JPT/CH-AS/7108

10th August 2015

Re: 31 Sea Way Middleton on Sea PO22 7RZ – M/56/15/HH

Proposed Elevations  
Sections B-B  
C-C  
D-D

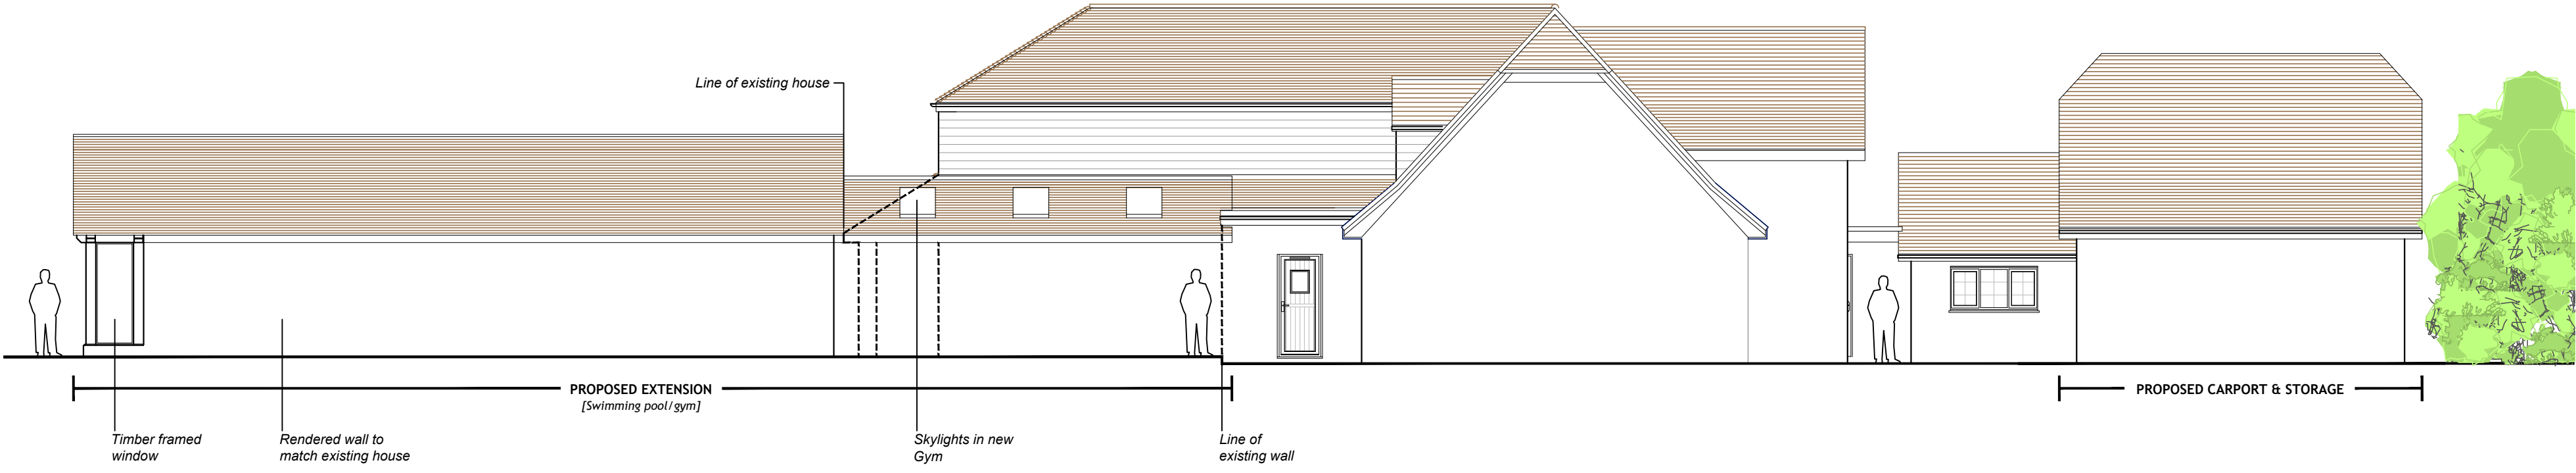
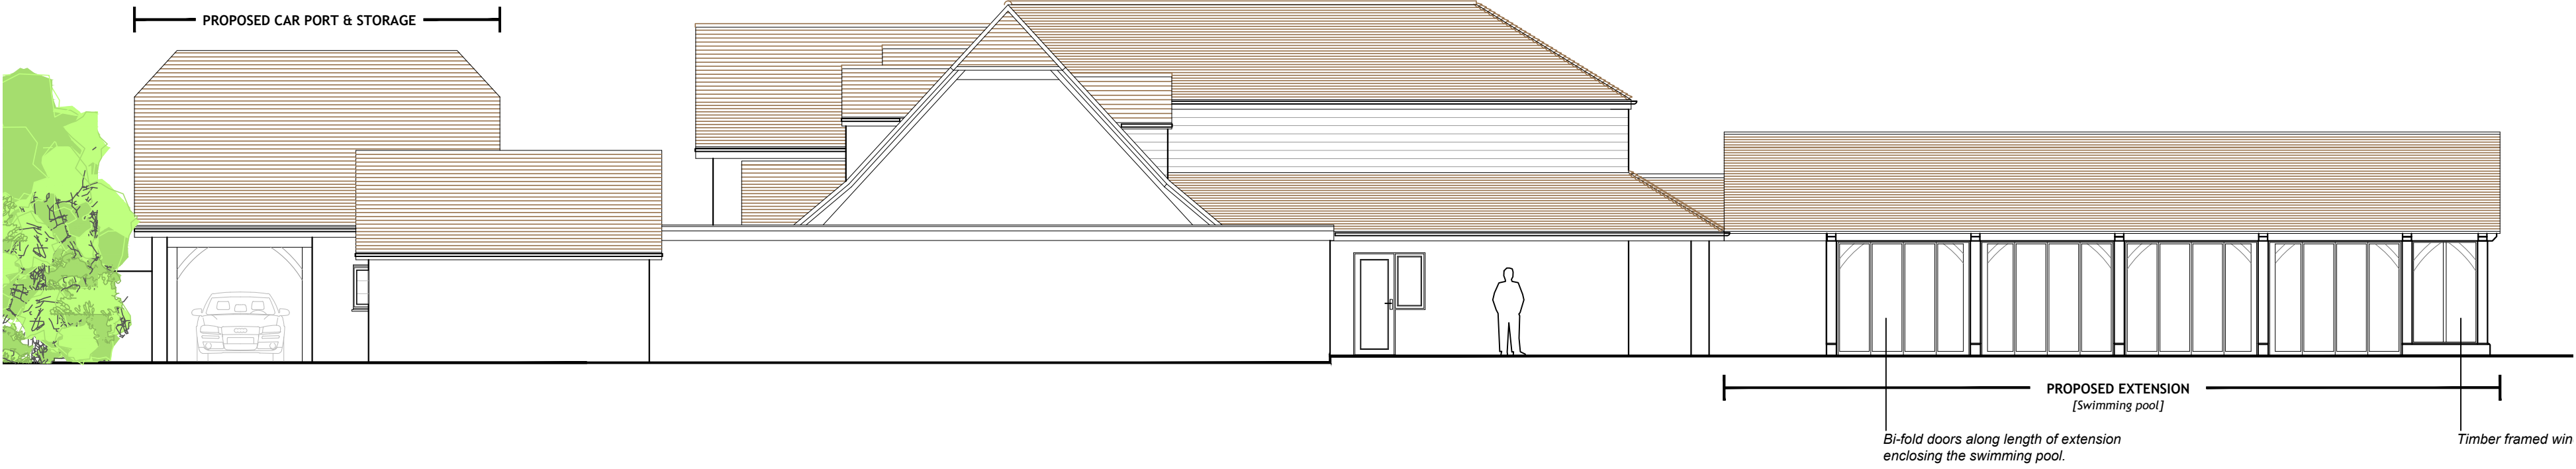
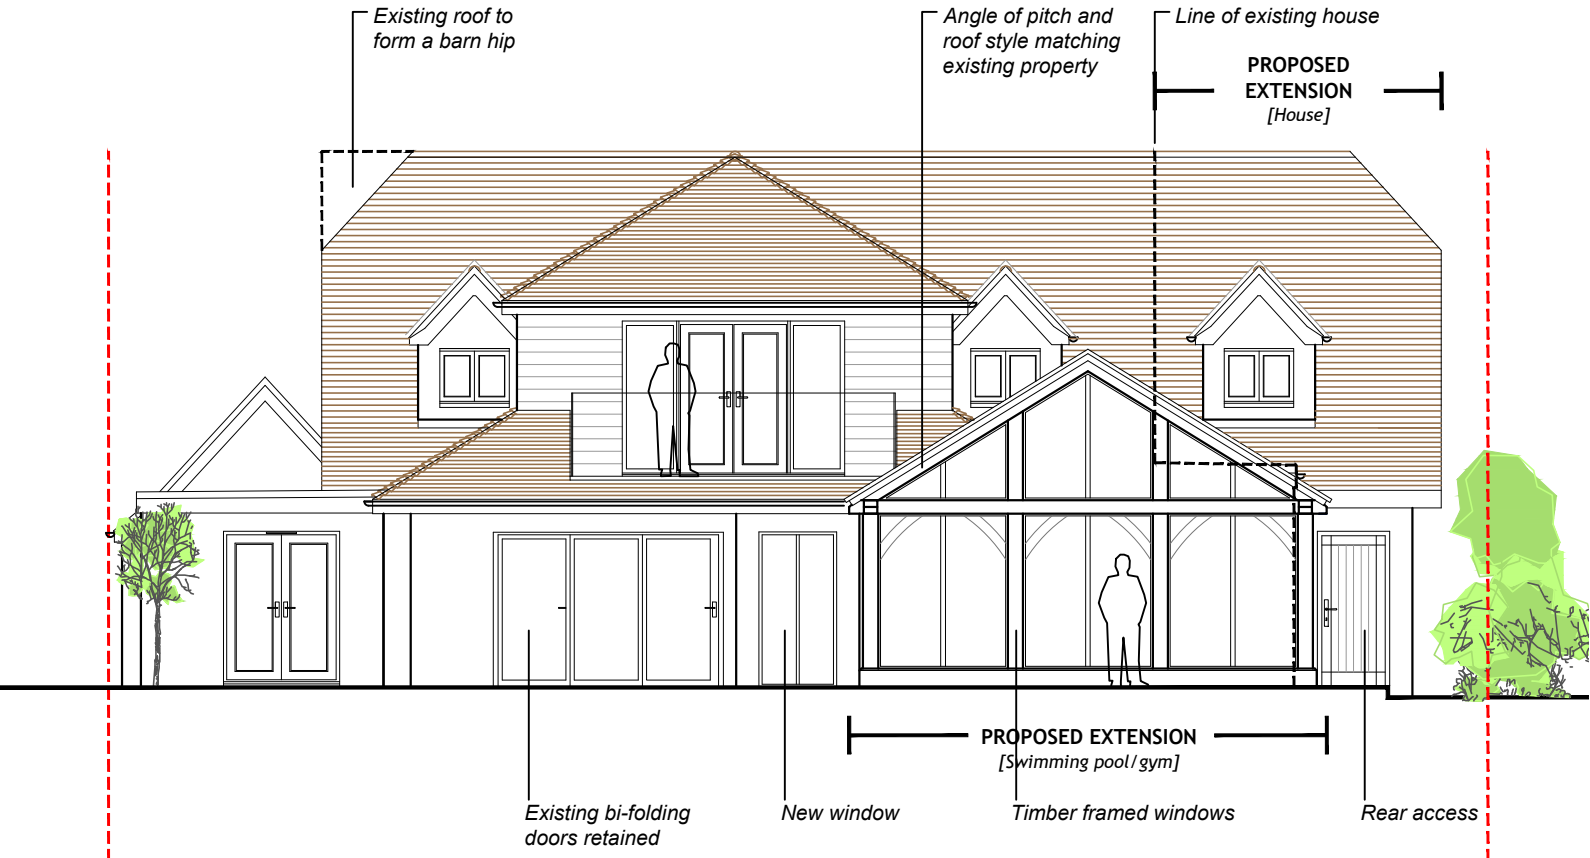
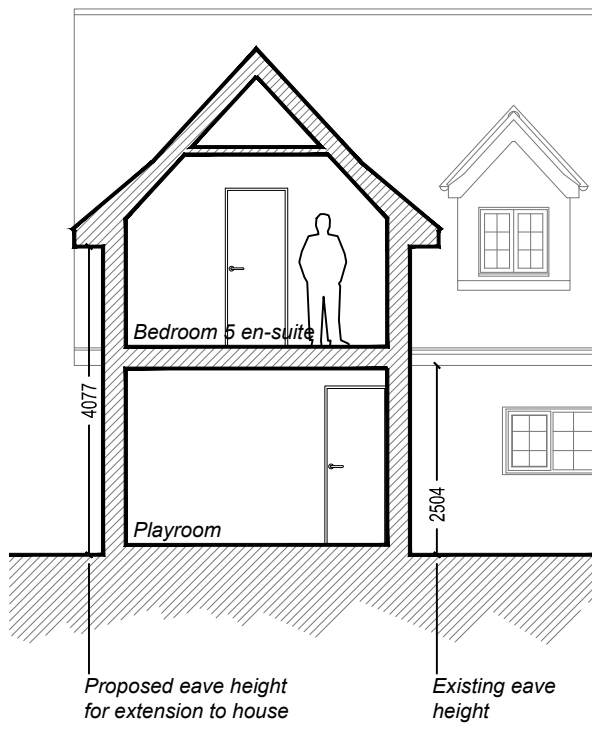
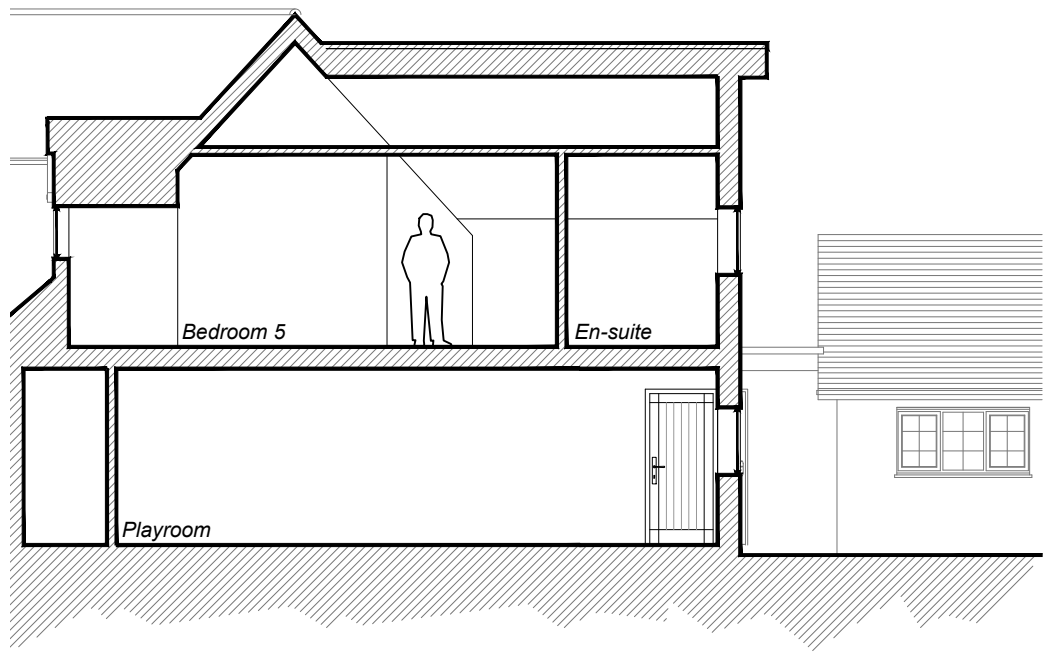
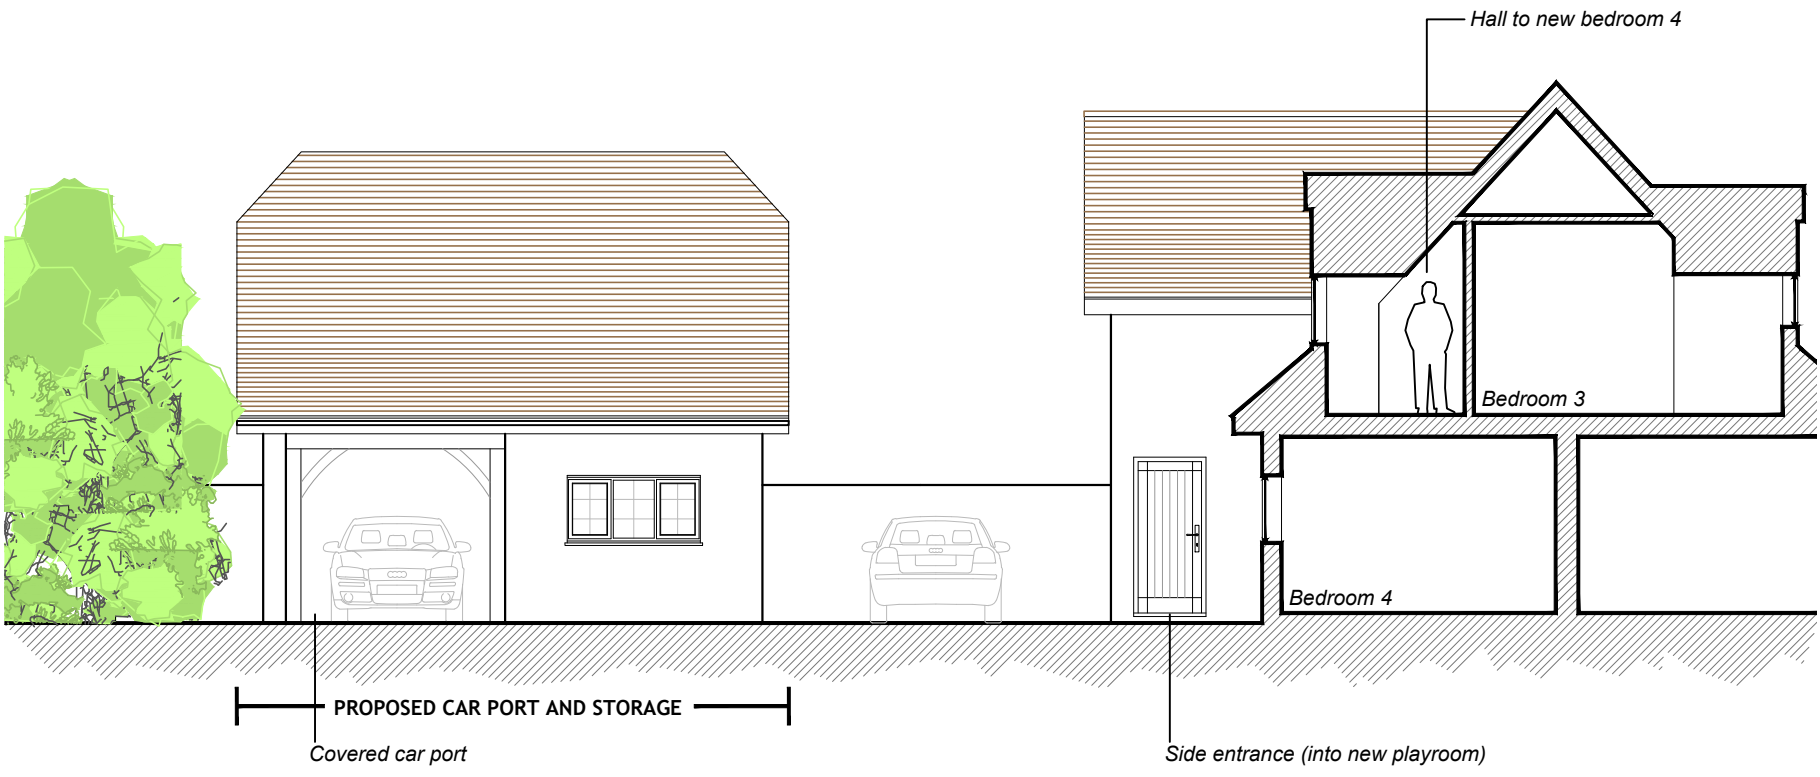
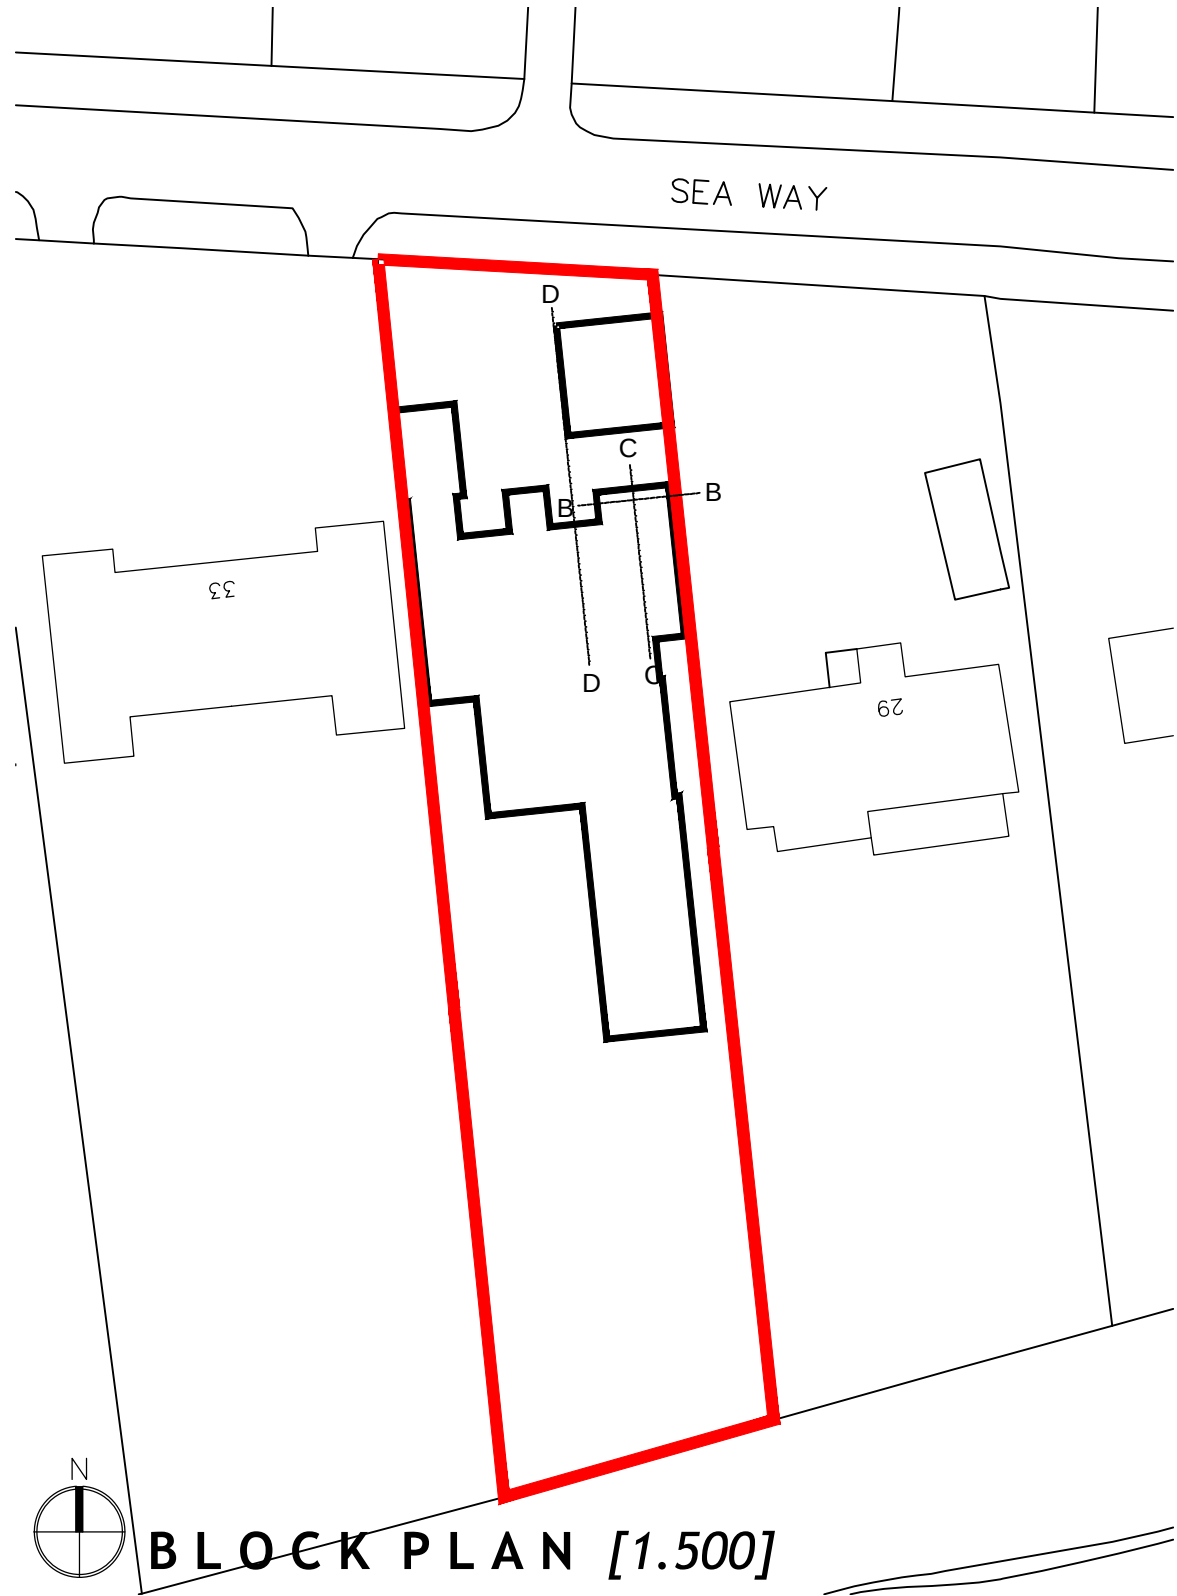
5. On this basis, the owner of No. 31 could remove the hedge, fencing and other details if this is not protected.
6. The reduction in height of the swimming pool structure is insufficient and inadequate to be considered as appropriate for this site.
